# **EAST YORKSHIRE SOLAR FARM**

**East Yorkshire Solar Farm  
EN010143**

**DRAFT Statement of Common Ground between East Yorkshire  
Solar Farm Limited and the Ouse and Derwent Internal  
Drainage Board**

**Document Reference: EN010143/APP/8.16**

FIGURE TITLE
Drain Names
Sheet 2 of 3

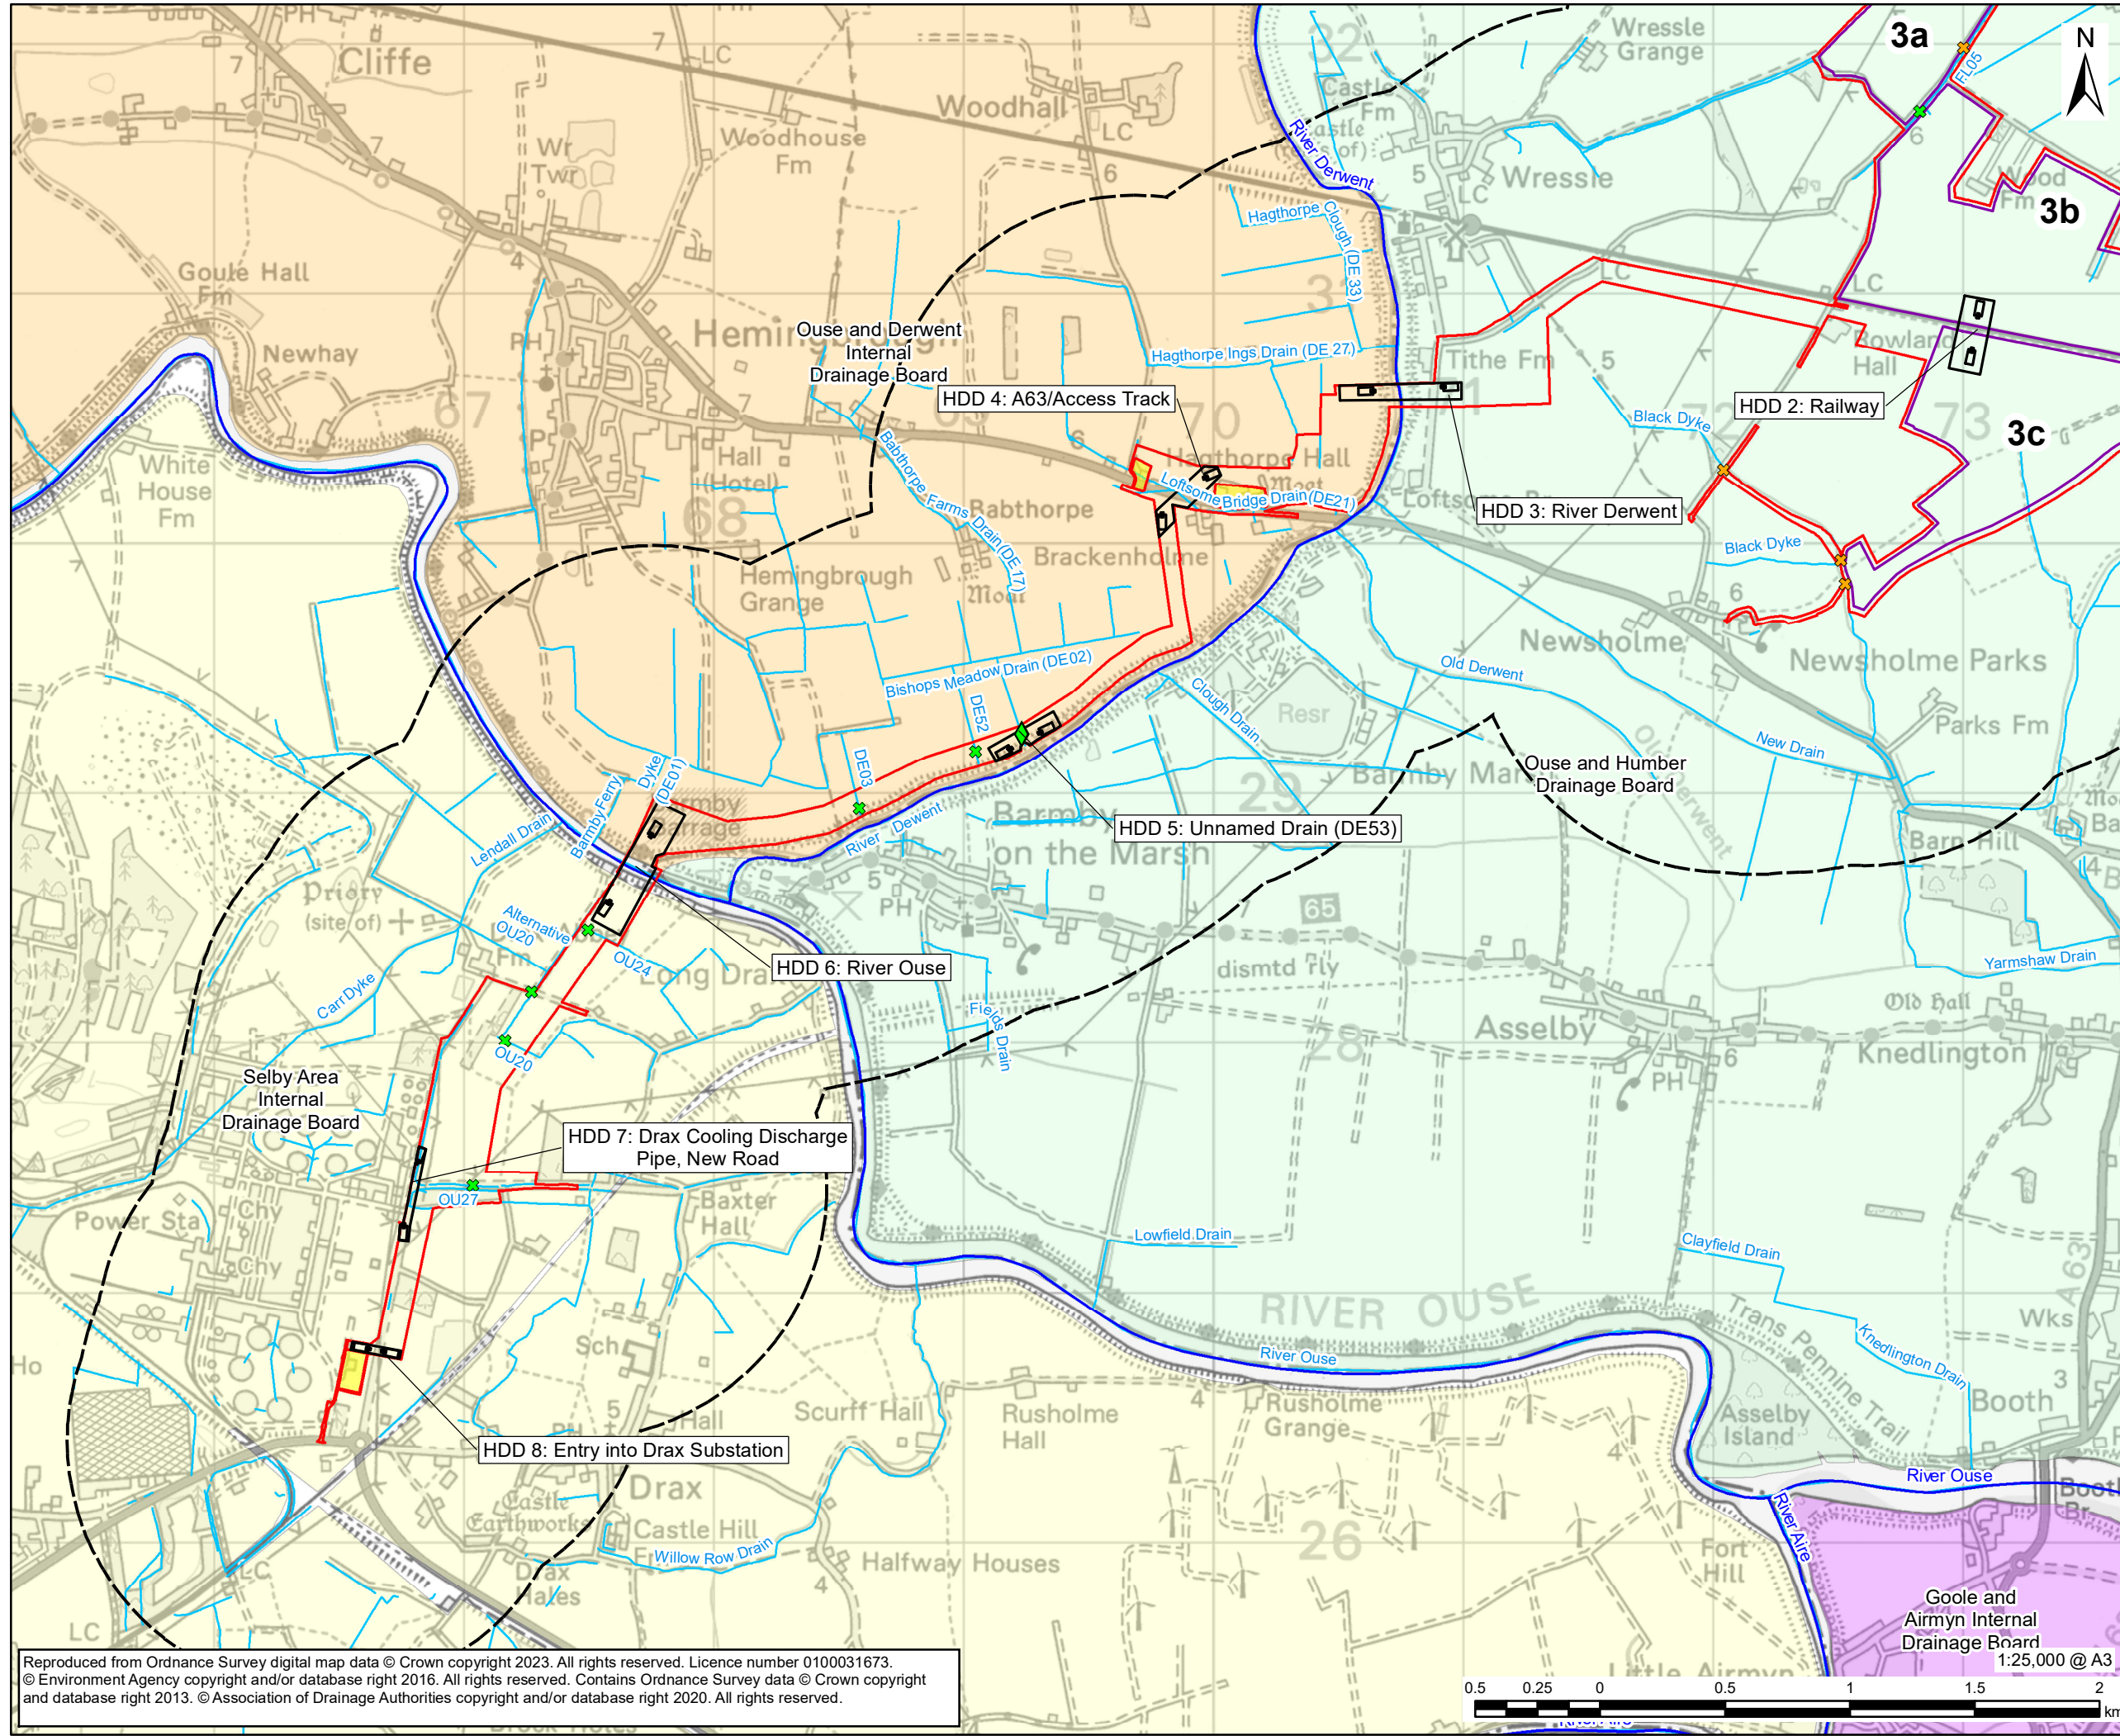
Ref	Relevant Application Document	Summary of Description of Matter	Ouse and Derwent IDB Current Position	Applicant Current Position	Status
3.1.3	Relevant Representation	Relevant watercourses	<p>The Ouse and Derwent IDB note that using Figure 9-2: Drain Names (Sheet 3 of 3), ES Volume 3 [APP-152], the Ouse and Derwent IDB will be looking at the below watercourses which may/will be effected: 1. Drain DE21 – this is the Ouse and Derwent IDB maintained watercourse known as Loftsome Bridge Drain. 2. Drain DE53 – this is the Ouse and</p>	<p>The Applicant accepts that the Ouse and Derwent IDB will be looking at the watercourses identified in their relevant representation.</p>	Agreed
